# Norfolk Boreas Offshore Wind Farm Revised Cawston Highway Intervention Scheme Road Safety Audit Decision Log

Applicant: Norfolk Boreas Limited  
Document Reference : ExA.AS-3.D5.V1  
Deadline 5

Date: February 2020  
Revision: Version 1  
Author: Royal HaskoningDHV

3. This RSA Decision Log Report provides a Designer's response to the outcomes from a stage 1 road safety audit (RSA) carried out on the revised Highway Intervention Scheme (HIS) for link 34, B1145 Cawston.

CAWSTON VILLAGE CENTRE - B1145
SCALE - 1:500

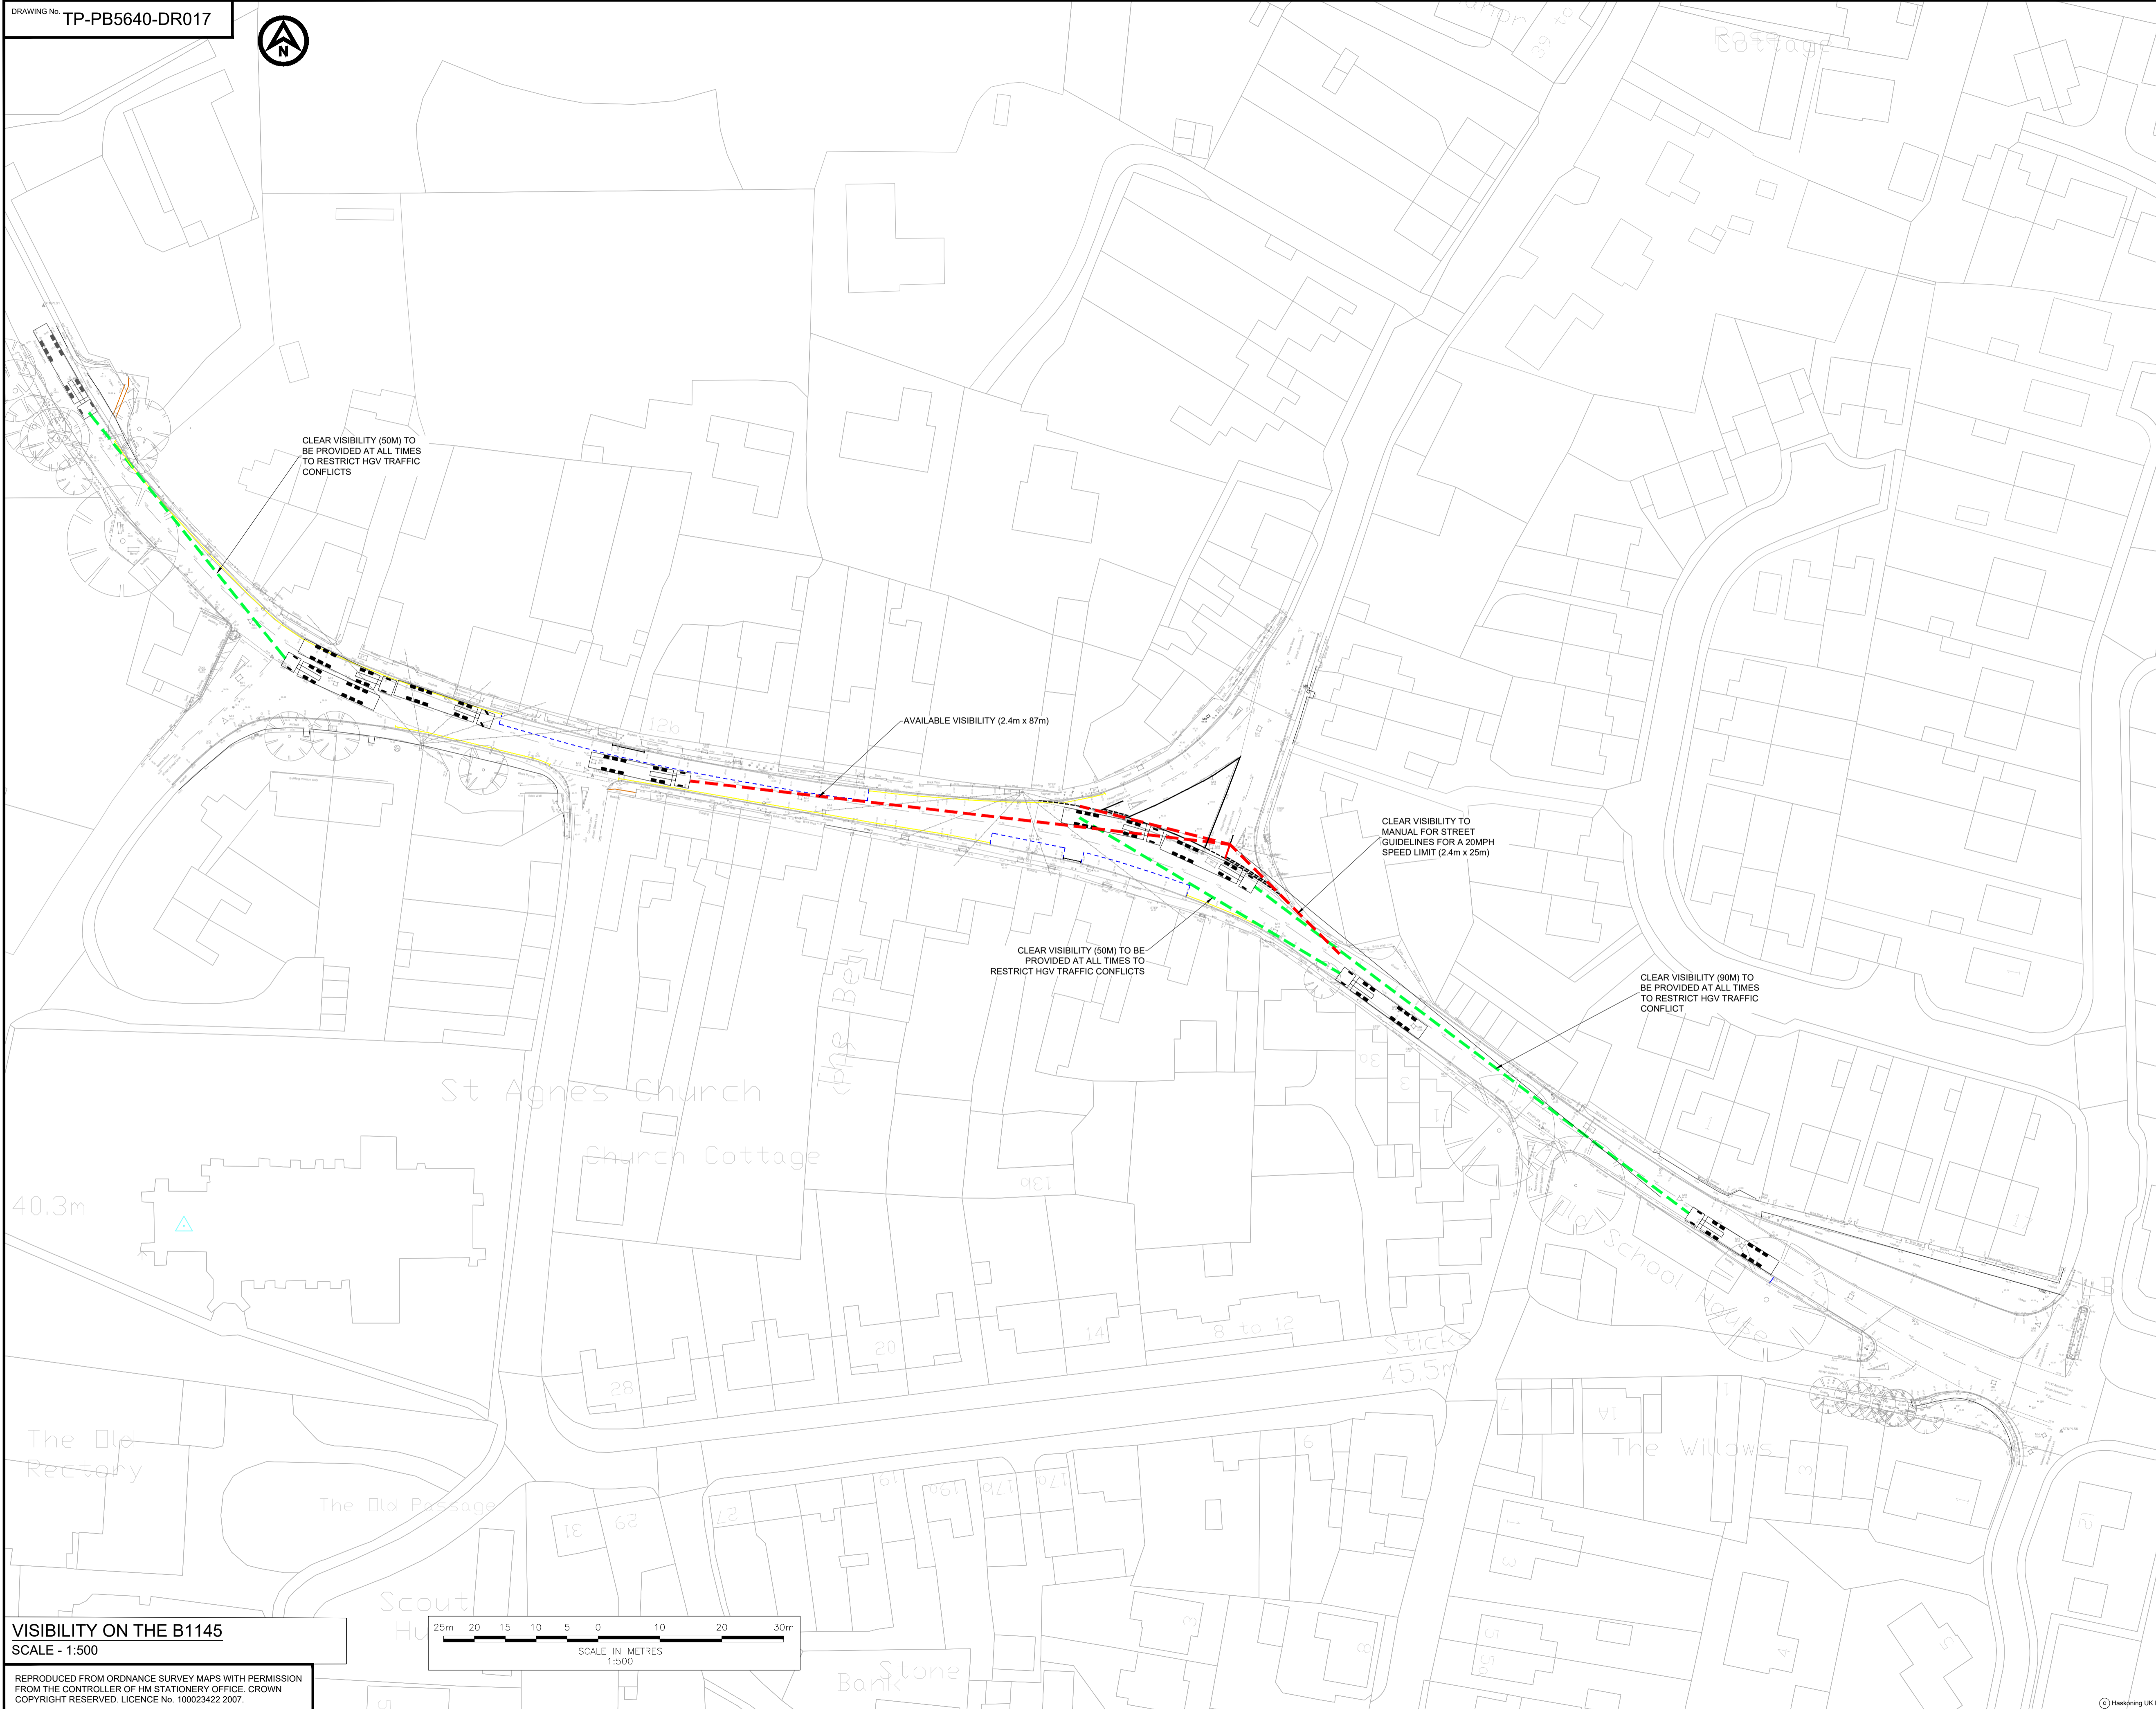
*The drawing provided makes no reference to the following:*

- *Ongoing Maintenance programmes – all visibility splays and proposed signage to be kept clear of vegetation.*

***RECOMMENDATION: It is recommended that an on-going maintenance programme is put in place to keep all visibility splays, footways and signage clear of vegetation.***

*Location: A – Chapel St*

*Summary: Introduction of a signpost may result in a pedestrian having to step into the carriageway.*

*Details: The Audit Team note that the drawings detail the introduction of a signpost and '20mph zone' sign to the footway in the vicinity of no 6 Chapel Street. No details have been provided to the exact location of the proposed sign; however, any signpost will reduce the already narrow footway. This may result in a pedestrian, particularly with a pram or wheelchair, having to step out on to the carriageway putting themselves at risk of conflict with approaching vehicles, or indeed personal injury.*

***RECOMMENDATION: It is recommended that the signpost is introduced to the widest area of footway and is positioned to the back of the footway to afford maximum footway area. The sign could be cantilevered on a rectangular backing board, to ensure post can be situated at the very back of the footway.***

*Location: B – High Street*

*Summary: Narrow footway and existing vegetation overhanging the footway will increase risk to pedestrians being struck by passing large vehicles.*

*Details: Whilst on site it was noted that the footway on the High Street between Norwich Road and Chapel Street is reduced considerably by existing vegetation. The perception of the width of the footway is already decreased by the proximity of the walls to the footway edge, which effectively reduces the width. With an increasing number of larger vehicles travelling through the village pedestrians will be at a higher risk of striking from HGVs.*

***RECOMMENDATION: It is recommended that the vegetation along this section of the High Street is maintained accordingly to provide maximum footway area to pedestrians.***

*Location: C – High Street*

*Summary: Narrow footway will increase risk to pedestrians being struck by passing larger vehicles.*

*Details: Whilst on site it was noted that the footway along both sides of the High Street is narrow. The perception of the width of the footway is decreased by the proximity of the houses and their railings/walls to the footway edge, which effectively reduces the width. With an increasing number of larger vehicles travelling through the village pedestrians will be at a higher risk of striking from HGVs.*

**RECOMMENDATION: It is recommended that the Design Team:**

- Introduce measures to highlight the presence of pedestrians within the area;**
- Introduce road markings and 20mph signage at the gateways allowing for maximum impact and awareness;**
- Provide maximum footway area, by attaching all signs to existing street furniture where possible and introducing any new signposts to the back of the footway, reducing footway clutter.**
- Review the compliance of drivers following the introduction of the reduced speed limits and introduce further measures if necessary.**

9. Agree with the recommendation.
10. The Applicant will comply with NCC's policy for grass cutting of visibility splays. The policy sets out a maintenance regime of five cuts between May and September in urban areas (defined as roads subject to less than a 40mph speed limit). A note will be added to the scheme drawings.

11. Agree with recommendation.
12. The sign is to be located adjacent to an existing concrete post that extends out into the footway from the residential property wall (no 6 Chapel Street). The post will be set at the back of the footway and thus will not interfere with the existing available footway width.
13. It is further agreed, that the rectangular sign would be cantilevered on a rectangular backing board to ensure that the post can be situated at the very back of the footway. Full details will be set out in the drawings submitted for RSA 2.

14. Agree with the recommendation.
15. The Applicant has sought guidance from NCC's policy with regards to vegetation maintenance, the most relevant being for highway verge grass cutting. The policy sets out a maintenance regime of five cuts between May and September in urban areas (defined as roads subject to a speed limit less than 40mph speed limit). A note will be added to the scheme drawings.

32. Agree with the recommendation.
33. The HIS will be updated to include the introduction of Diagram 544.1 'Pedestrians in the road ahead' at the same location (on the same posts) as the Diagram 516 'Road narrows' signs. This will have maximum impact by raising motorist awareness of pedestrians prior to traversing the sections of High Street with the narrowest footway.

34. Agree with the recommendation.
35. The HIS will be updated to introduce the 20mph signing at the gateway features. The detail of the gateway features will be developed for RSA 2 in consultation with NCC with the potential for Cawston Church of England Primary to be involved as part of a road safety educational programme.

36. Agree with the recommendation.
37. The quantum, location and form of signs and location of signposts has been carefully chosen to minimise street clutter, conservation impact and not compromise footway width. Full details of sign/post sizes and residual footway widths will be provided for RSA 2.
